Submissions to EIS		
Issue #	Issue	Draft response
DP&E 1	The justification for contravention of the height development standard in the Warringah Local Environmental Plan 2011 has not been satisfactorily argued. Further assessment is required detailing how both the community health centre building and car park structure impacts on adjoining sensitive receivers when considering the objectives of Clause 4.3 of Warringah LEP 2011	Listed adjacent are the objectives of clause 4.3 height of buildings. As noted in the EIS, the height and design of the building is a function of the services provided. In terms of the increased height, the proposal is considered to meet the objectives of the control for height of buildings as follows: (a) The proposed building is comparable to the height and scale of many of the recent new developments along Pittwater Road and Warringah Mall opposite. The site is within an area undergoing change in the urban fabric and the proposed development will provide a land mark building for the delivery of primary health services to the Warringah Community. It is considered that the proposal is compatible with the newer developments in the surrounding area and will be

2 ELEVATION - MAIN BUILDING SOUTH
1 : 200

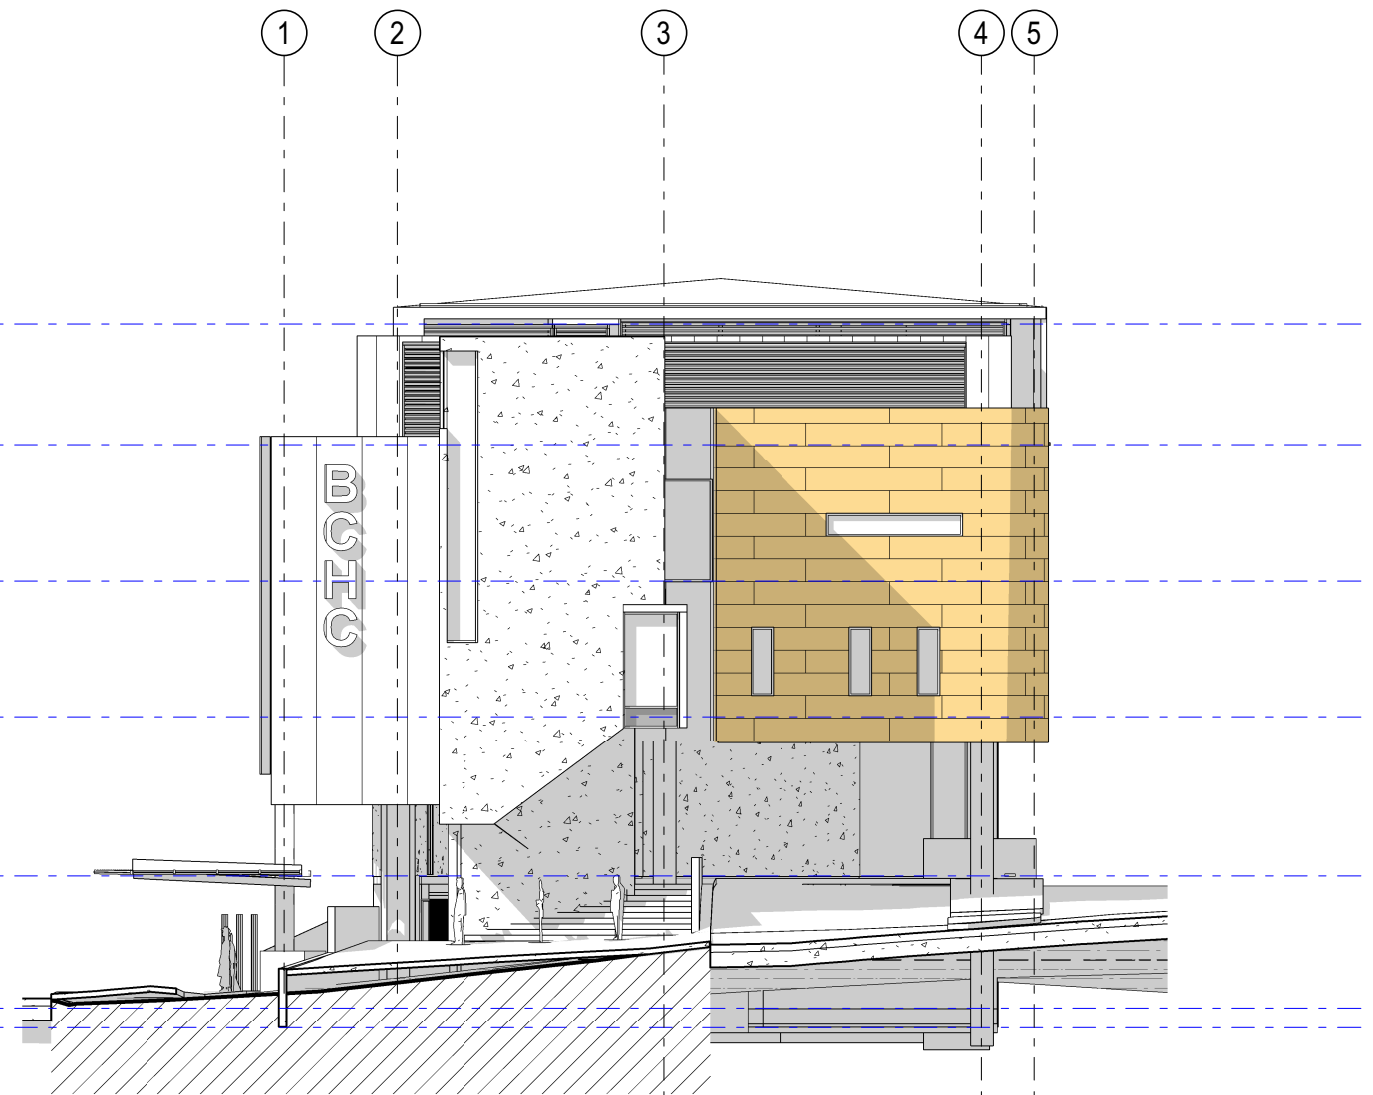
Council -4	The block stairwell on the southern elevation facing William Street should be incorporated into the building rather than being attached to the front of the building; otherwise, a more innovative treatment of this structure should be investigated to improve the aesthetics of the building. Council is seeking a clean and simplified building form on the southern elevation.	Incorporation of the southern stair into the building would significantly compromise clinical space at that end of the building and would require greater floor area to avoid compromise in clinical functionality. Additional floor area and the associated cost was not available to the project or the site and the form of the stair outside of the main build form is considered appropriate for this location.
Council -5	Due to the solid treatment of the block stairwell material (on the southern elevation) and the 5 storey 'chimney' like effect, it does not present a fitting 'gateway' statement to Brookvale. A better approach will be to integrate the stairwell into the main building form presenting a more organised and less busy looking corner. The corner building signage can also work better with this 'cleaner' minimalist building aesthetics.	Please refer to comments above.
